Your Ref: OWPC23593
Our Ref: WA/54/19/NMA 12-06-2019
Please ask for:
Zac Denton

Non-material amendment following the grant of reference WA/84/17/PL for change of colour of wall cladding and infill open bay with sectional door.

Fairmead Farm Land Binsted Lane Binsted Arundel

DRAWING No.
RA / 674 / 100 D

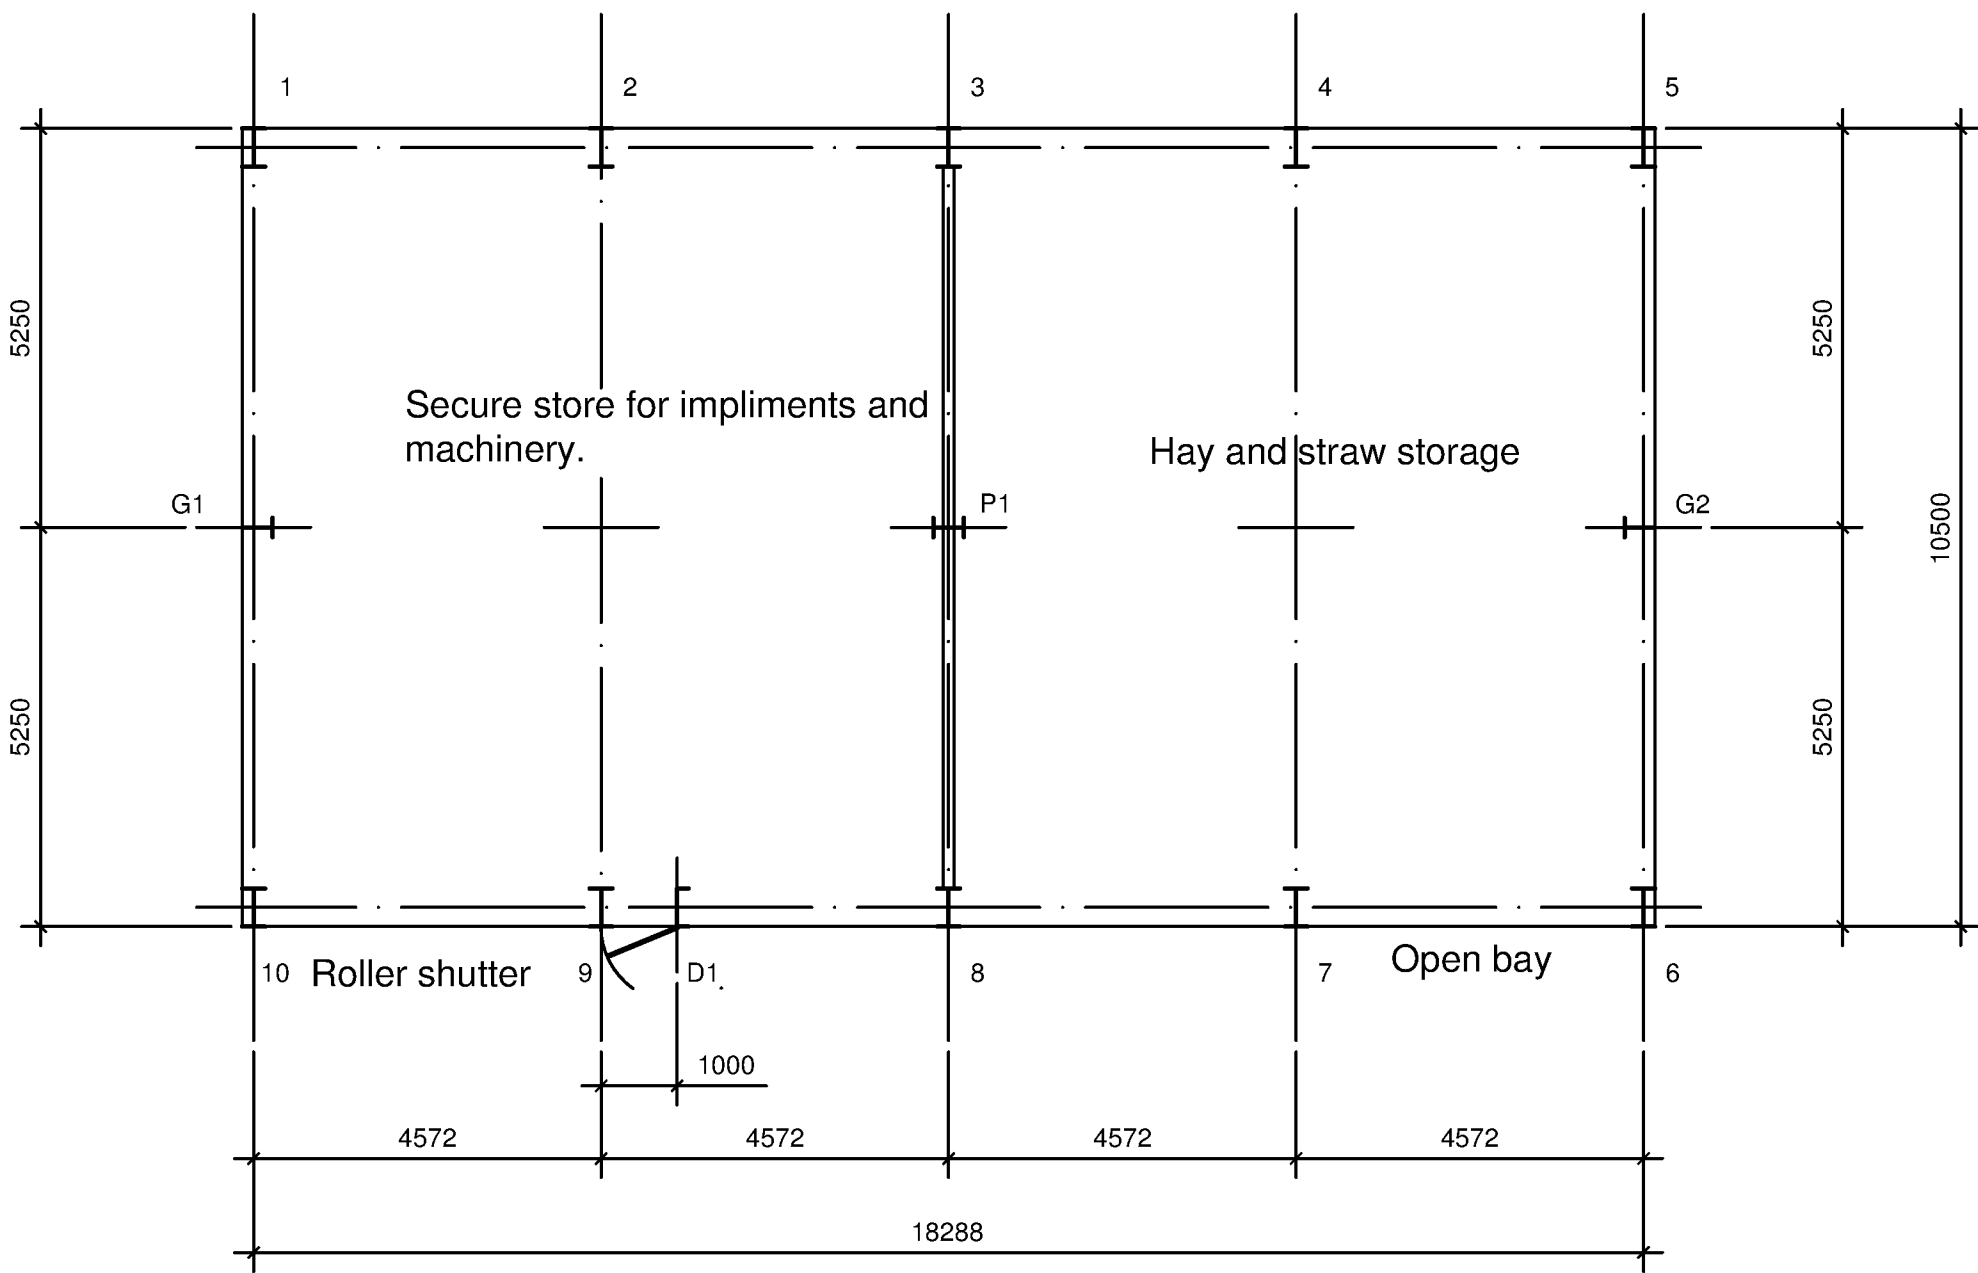
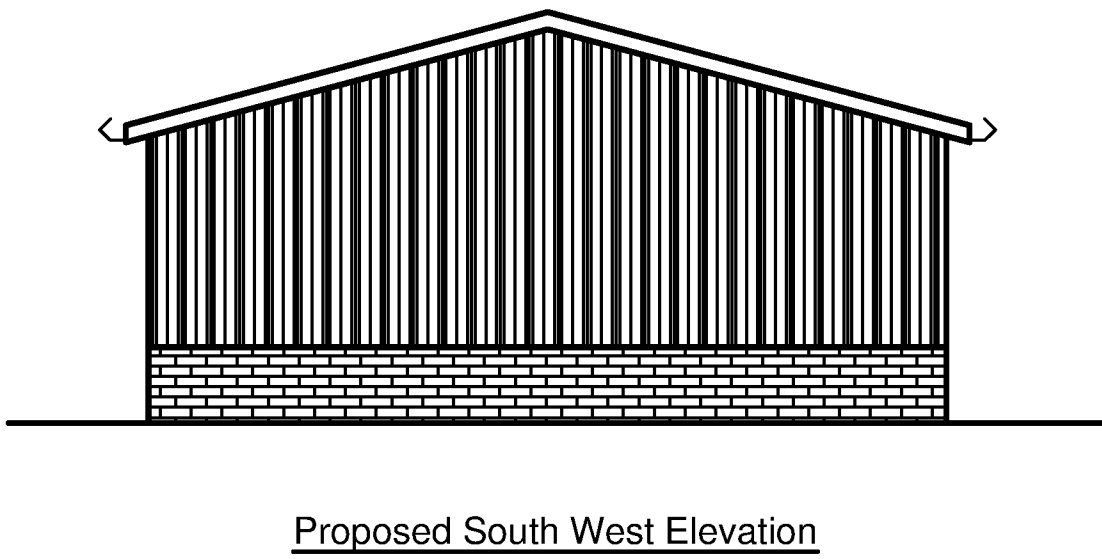
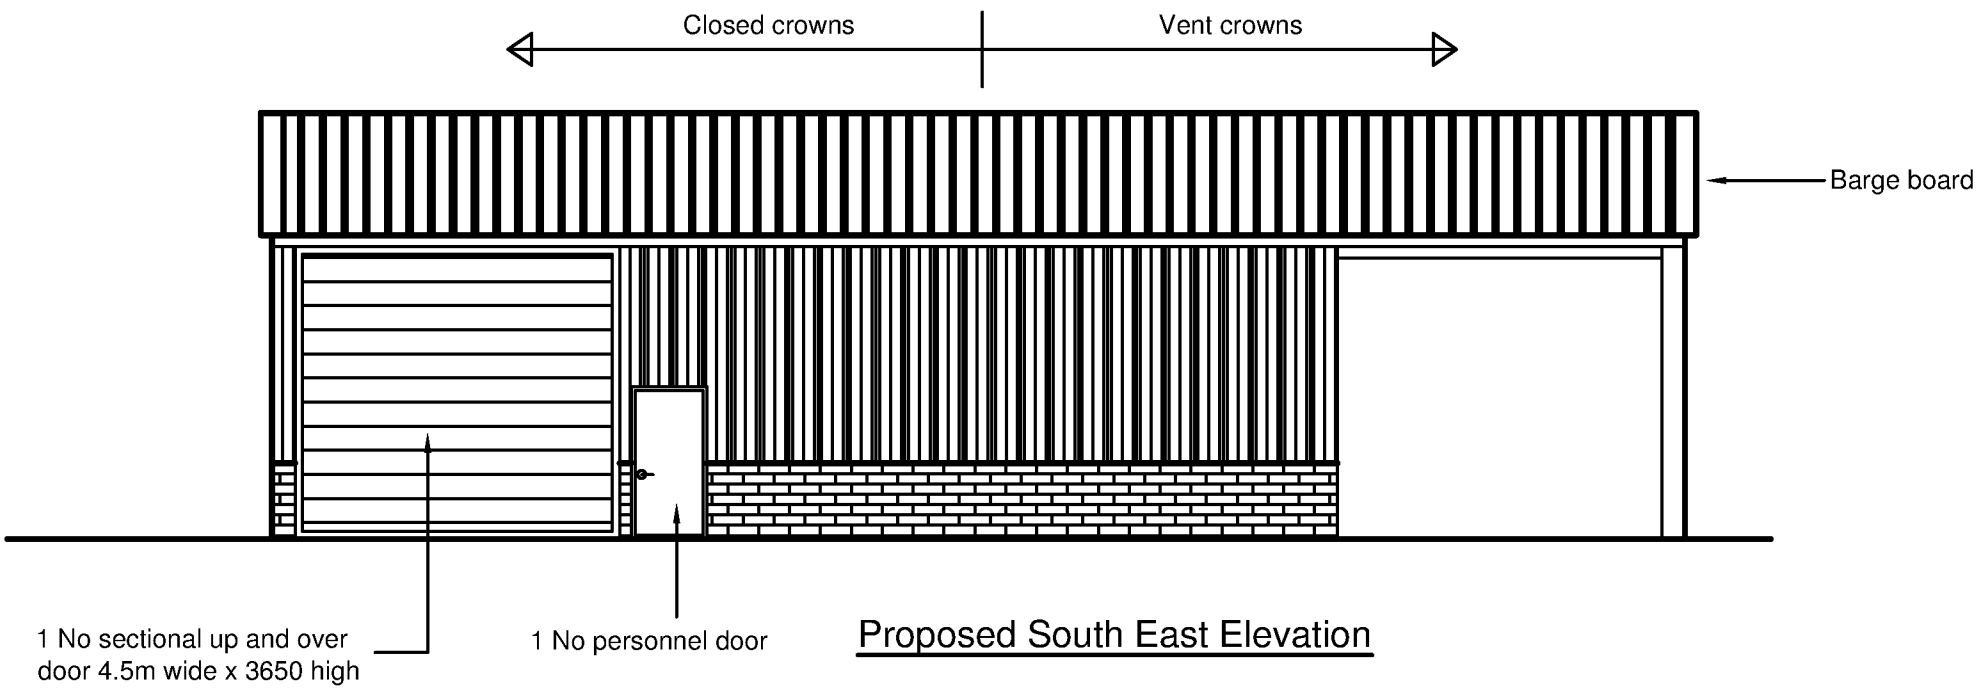
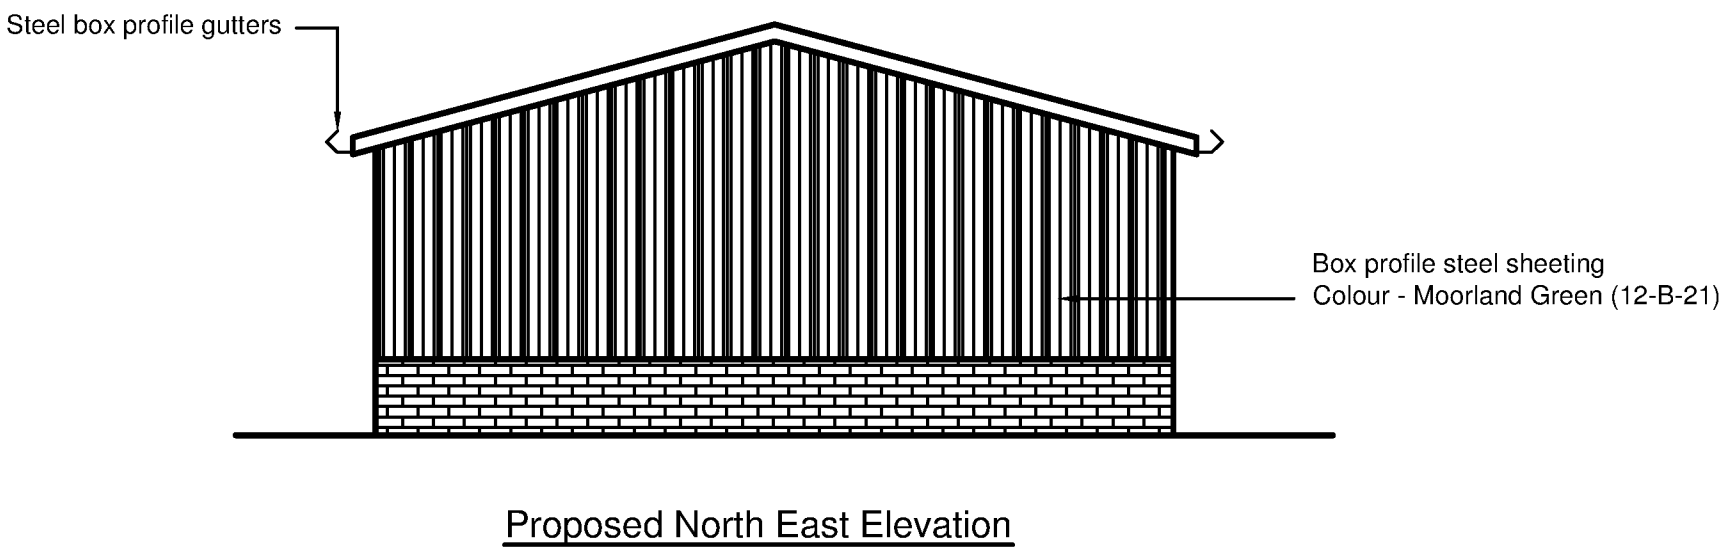
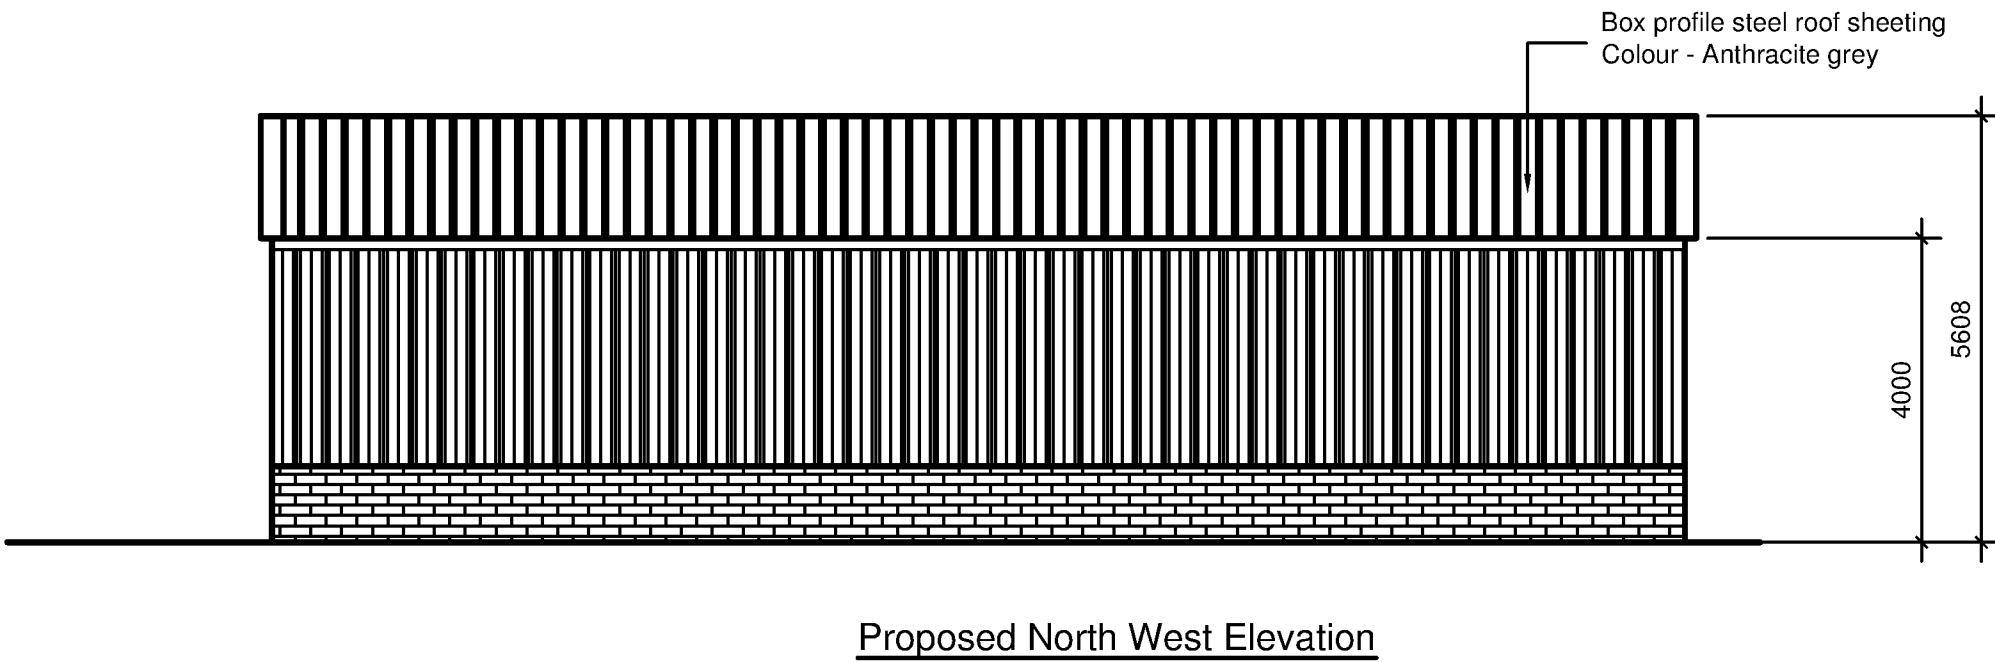
We think this requested amendment infers a change of use to the original planning permission given, which was to support farming use only on the site that the proposed building was located. An amendment to add a roller shutter door to a Hay and Straw storage area is totally unnecessary, unless the owner intends to keep other than the intended feed/bedding materials in that area. ie storage of additional machinery for external contractual purposes.

To change the colour of the building to other than green to would be out of keeping, particularly in its location adjacent to a Grade II listed building and the surrounding open countryside.
